Application no: H22/0717/97

Description: Erect detached dwelling with
detached garage (Plot 1)

Location: Oakleigh House, High Road
Weston
Spalding
Lincs

Amendment: Increase in size of detached garage
Dwg Nos. 970605/P2A and 95014/001F

DATE 06-97 DRAWING No. 970605/P1

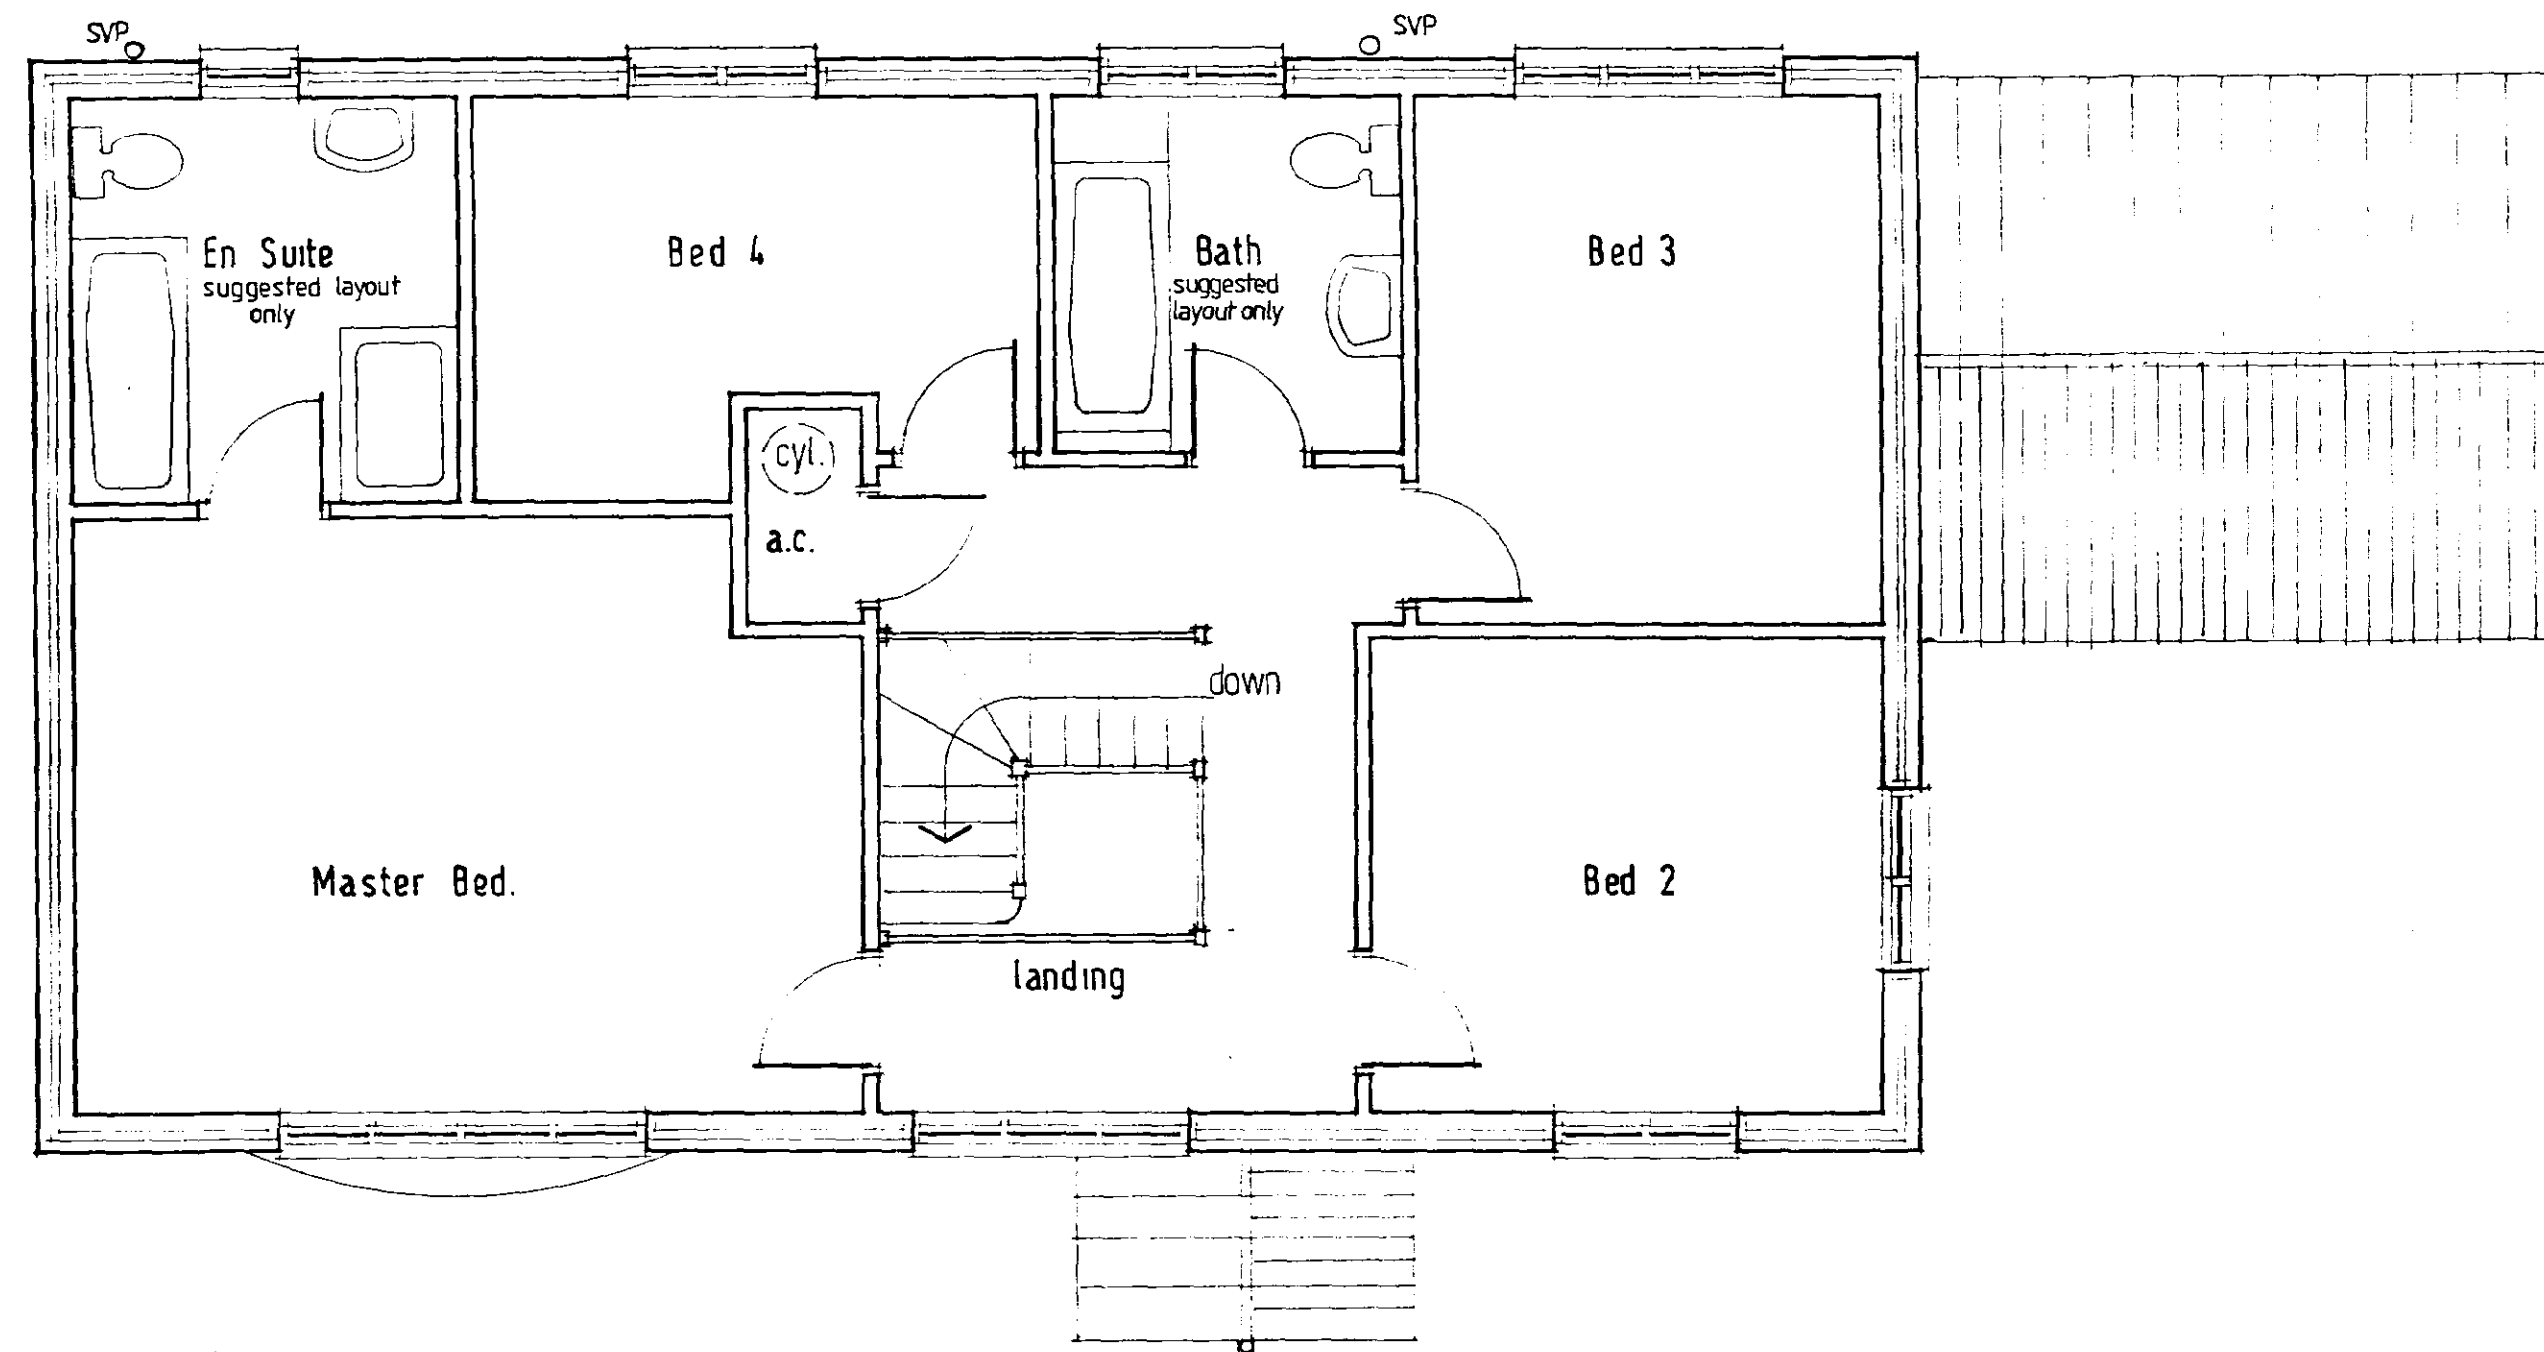
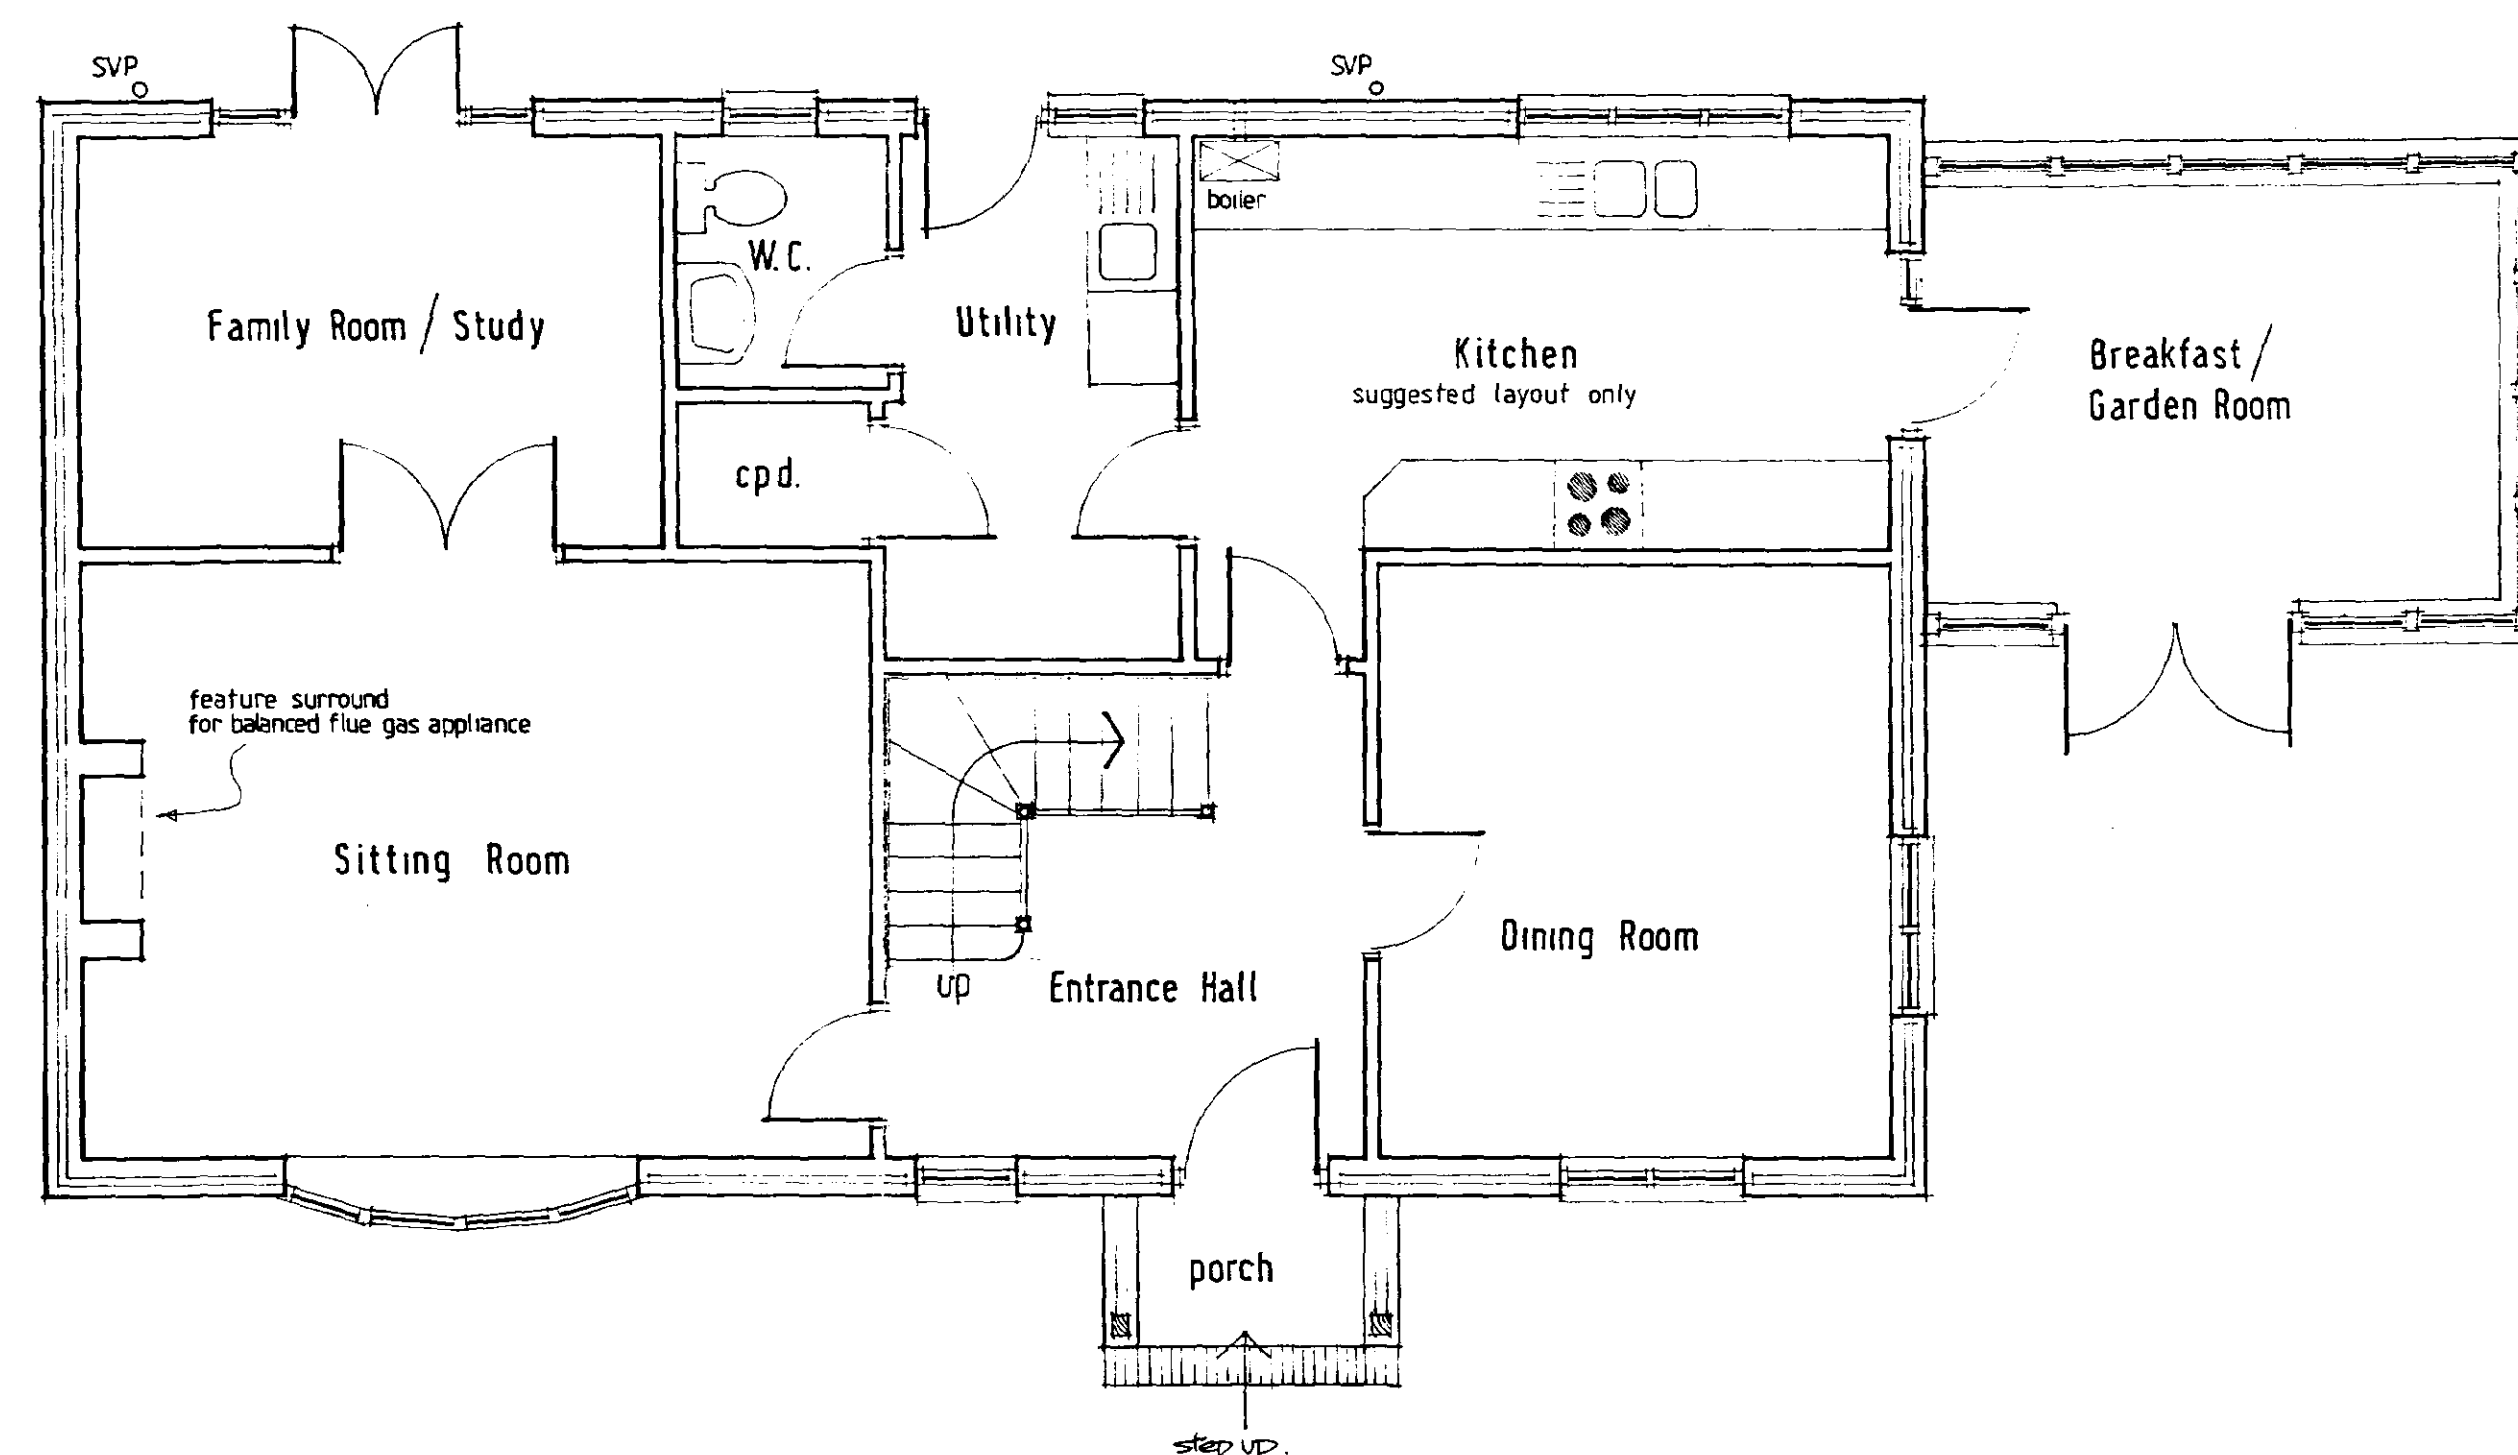
Amendment: Change facing brick from Hanson Kempton Salisbury Stock
to Hanson Bizet Multi

REVISED FACING BRICK SPECIFICATION
PREVIOUSLY APPROVED - HANSON KEMPTON SALISBURY STOCK
NOW PROPOSED - HANSON BIZET MULTI
(AS SAMPLE SUPPLIED TO J. BLACKBURN
1/7/98)

The amended details submitted in respect of the above proposal have now been considered, and I am able to inform you that there are no objections to the amendment being implemented to the extent described above.
